With this resubmittal, CGS received a request to provide Review Comments (Email dated April 8, 2024); Letter of Intent (N.E.S., Inc., April 2024); Sketch Plan (N.E.S., Inc., March 19, 2024); Soils and Geology Report (HDR, March 2024); and other documents. The applicant requests a Sketch Plan to permit a new railroad spur through the property to service Fort Carson and associated railroad-oriented heavy and light industry and commercial uses that encompassing 3100 acres of land. CGS addressed the majority of these concerns in our comments dated October 30, 2023. Since then, HDR revised their soils and geology report, however, our concerns were not addressed and are generally repeated with additional comments included herein.

Submitted 4/29/2024 by Amy Crandall, Engineering Geologist, Colorado Geological Survey (303-384-2632 or acrandall@mines.edu)

#### SOILS & GEOLOGY CONDITIONS, CONSTRAINTS & HAZARDS

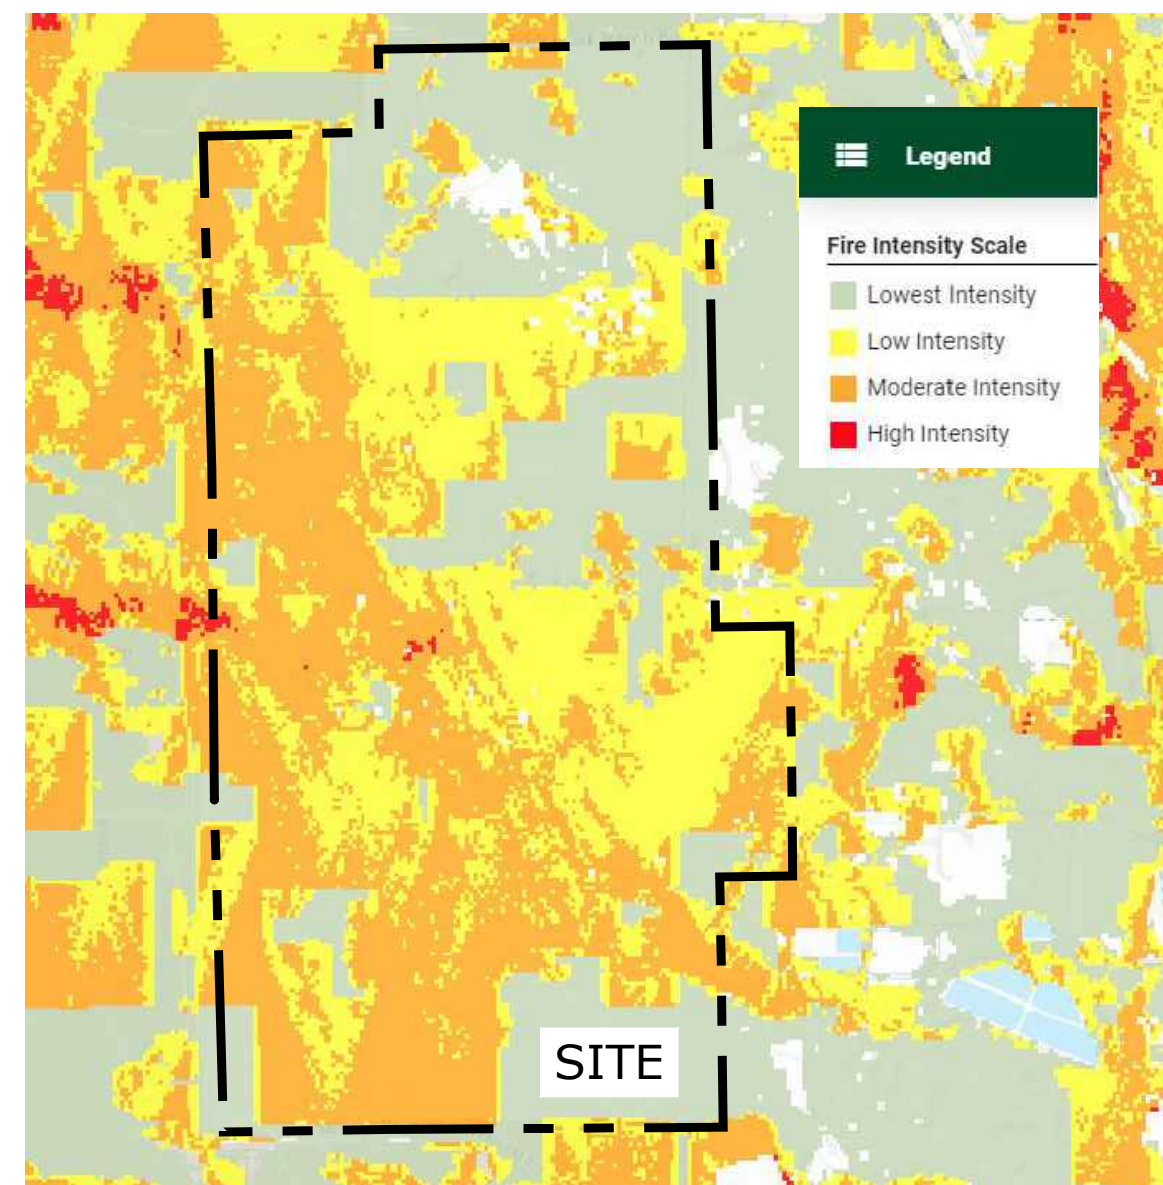
Soils and geology study: HDR's soils and geology study, while informative, does not fully meet the requirements listed in the El Paso County Land Development Code (LDC) for a comprehensive Geology and Soils report (Section 8.4.9). No test borings/pits were performed during HDR's field investigation, however, HDR states (p. 8), "HDR recommends performing additional geotechnical borings to further evaluate the subsurface conditions." Per the LDC, a map consisting of geologic hazards and constraints should be provided in the geology and soils report. Expansive soil is a significant geologic constraint that should be thoroughly addressed (borings and laboratory testing).

Debris flows: HDR states (p. 4), "In accordance with the Colorado Geological Survey Map ON-006-12, the project site is located immediately east of mapped potentially dangerous debris flow regions." Areas with conditions favorable for the generation and deposition of debris flows exist in the northern portion of the development (Lots 32 and 33). Additionally, young alluvial fan deposits and alluvial mud-flow deposits are mapped within the development (CGS publication OF-17-05, 2017). Debris flows/mud flows are geologic hazards that should be addressed in the geology and soils report.

- The soils and geology report is expanded/updated to include all the geologic hazards and constraints to development (i.e., debris flows, mudflows, mines, expansive soils, etc.). Figure 3 should be updated to include available geologic mapping for the area.

SKETCH PLAN OVERALL MAP

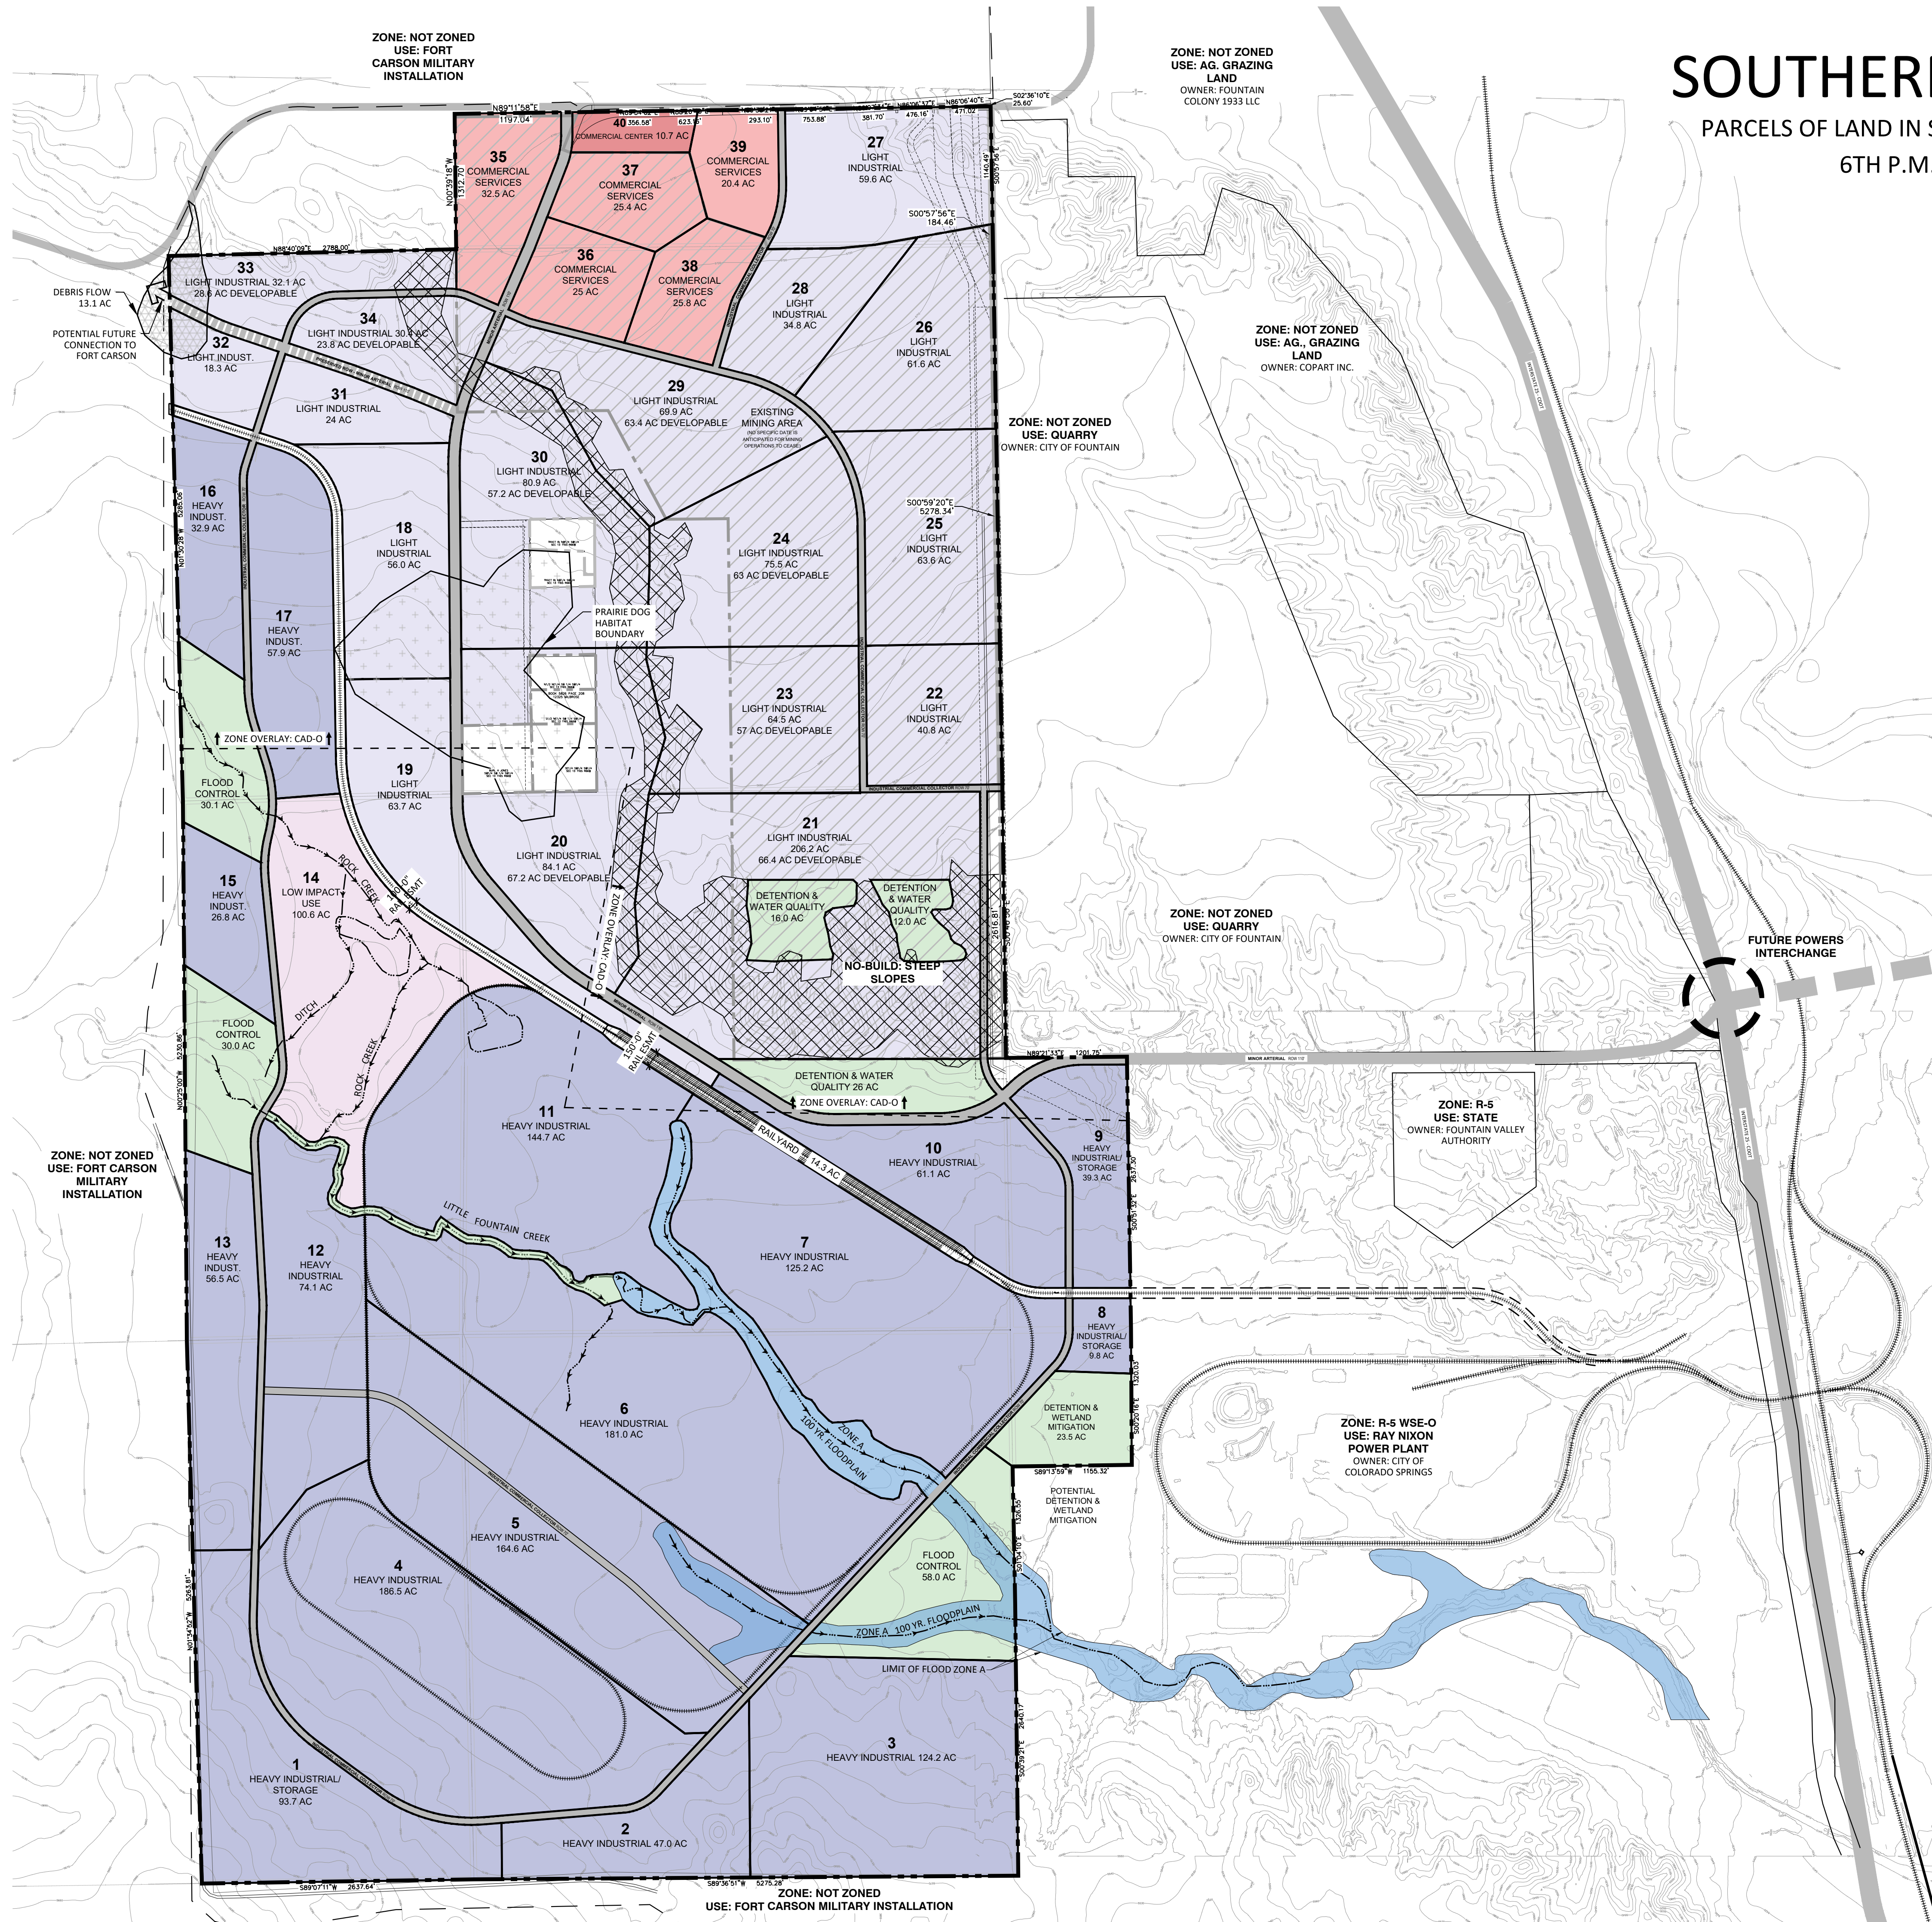
Permitted mines: The letter of intent and HDR report indicate that the permitted sand and gravel mines should not pose a danger to future development in the area as the operations are setback from the proposed development area. However, Lots 22, 29, and 30 contain permitted sand and gravel mines, and it is unclear where the development will occur in relation to these mines. A thorough investigation of the gravel pits that were noted by HDR and included in available geologic mapping should be performed if development will occur in these areas with mitigation measures presented.

- Further investigation and consideration of the permitted mines shown in Figure 4 of HDR's study should be provided with appropriate mitigation measures.
